Our Ref: EP/26/12/

1st March 2012

**Construction of new bay window to replace previously approved 2 storey extension
EP/54/11 to front of property
8 Westfield Avenue East Preston**

PROPOSED BLOCK 1:500

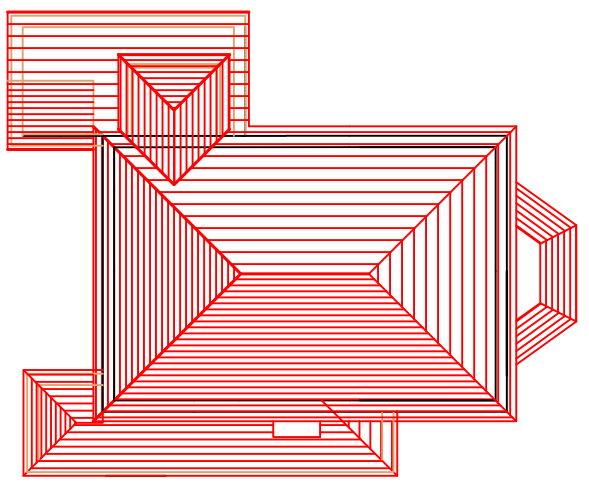
I require 1 electronic or 3 paper copies of a revised block/site plan to include 1 named road in accordance with the guidance notes available on our website detailed below (click on National List).
